CITY OF ALBUQUERQUE

April 30, 2025

**RE: 2540 Alamo Ave NE
Grading & Drainage Plan
Engineer's Stamp Date: 04/15/2025
Hydrology File: M16D045
Case # HYDR-2025-00136**

GRADING AND DRAINAGE:
EXISTING CONDITIONS

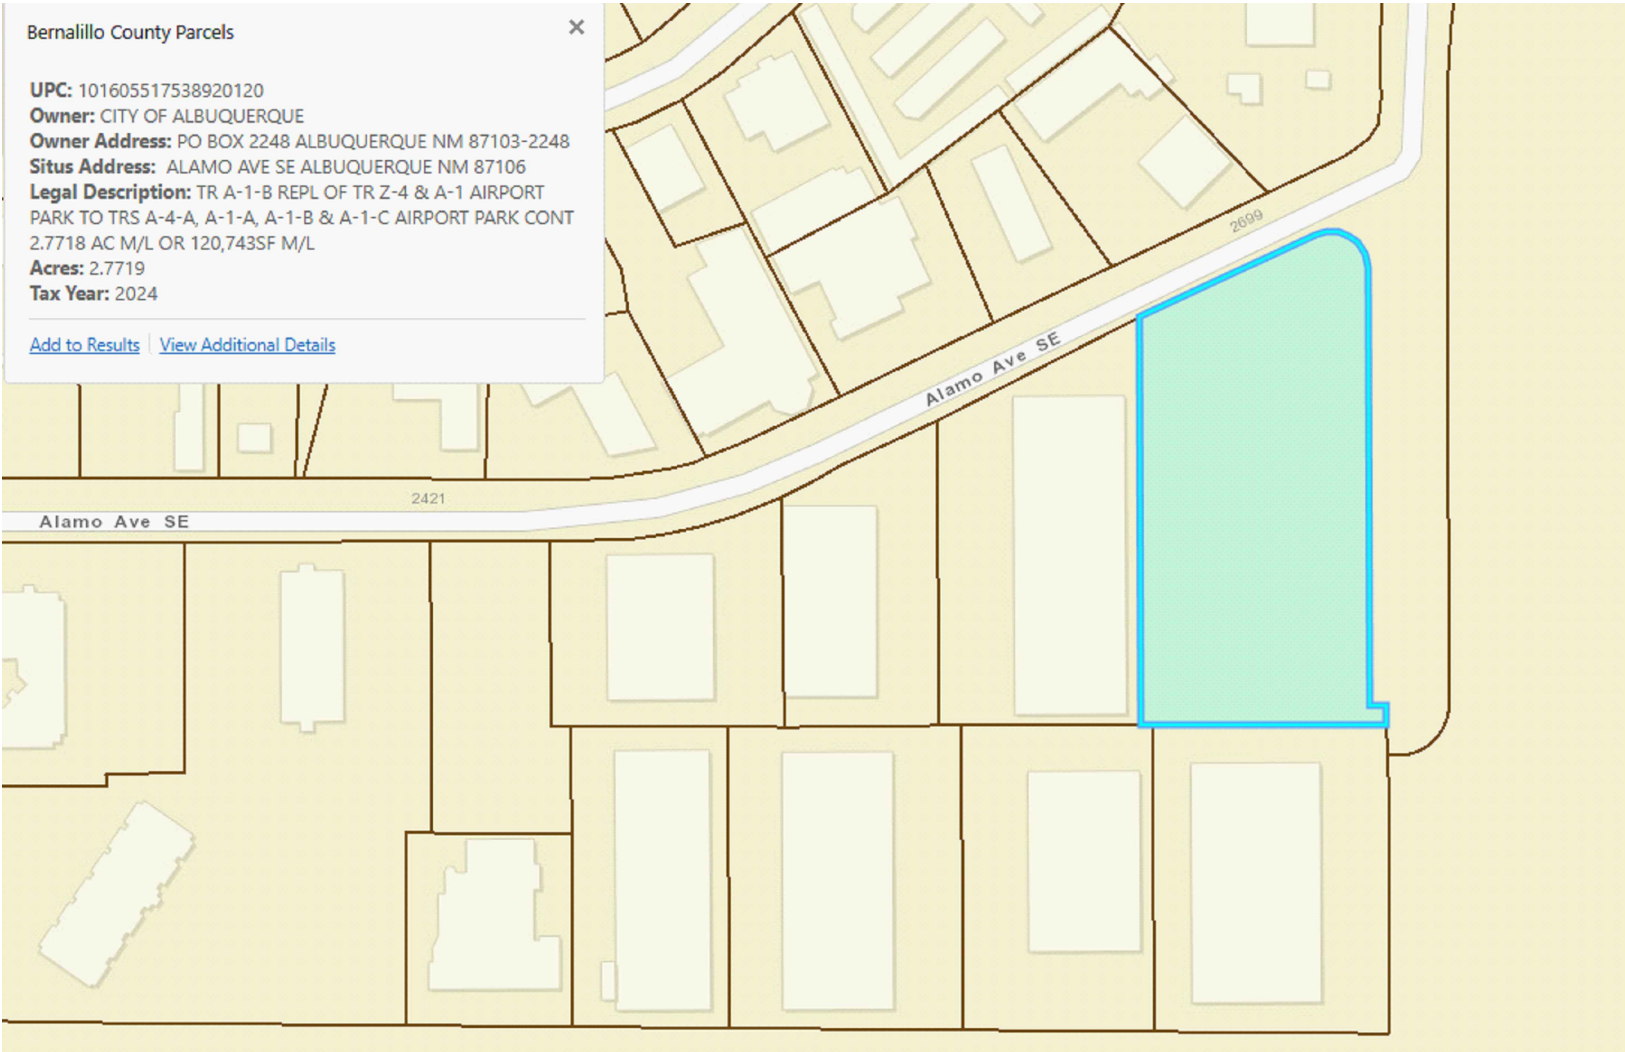
1. Include project benchmark and datum.
2. Please provide the FIRM Map and floodplain note with effective date.
3. Please provide the legal description of the property.

4. Please provide a Vicinity Map. This can be downloaded in pdf format from the City of Albuquerque's website.
5. Remove note stating No retention pond is required. This is misleading as there will be a storm water quality detention pond that is required for all development.

6. Provide management onsite for the Stormwater Quality Volume (SWQV) in accordance with the new drainage ordinance, § 14-5-2-6 (H). Please show the top and bottom of the ponds along with the volume for each pond. The onsite drainage should be directed to these ponds prior to being collected in a private underground drainage system. Please follow the DPM Article 6-12 Stormwater Quality and Low-Impact Development for the sizing calculations. To calculate the required SWQV, multiply the impervious area draining to the BMP by 0.42 inches for new development sites and 0.26 inches for redevelopment sites. The calculations of both the required and the provided volume of each BMP must be shown on the Grading and Drainage Plan. Each BMP should be labeled on the Grading and Drainage Plan with the required SWQV and associated water surface elevation and the 100-year water surface elevation. Landscaping of surface BMPs is also required to be noted on the Grading and Drainage Plan.

7. Please provide the SWQV calculations for each basin draining to each pond. The stormwater quality ponds need to be sized for the areas draining to them.

8. Show the driveway on the plan.

9. Please provide more details in the site's conditions. See the DPM Section 6-14(B) Drainage Submittal Criteria and Part 6-14(C) Grading Plan Checklist for details.
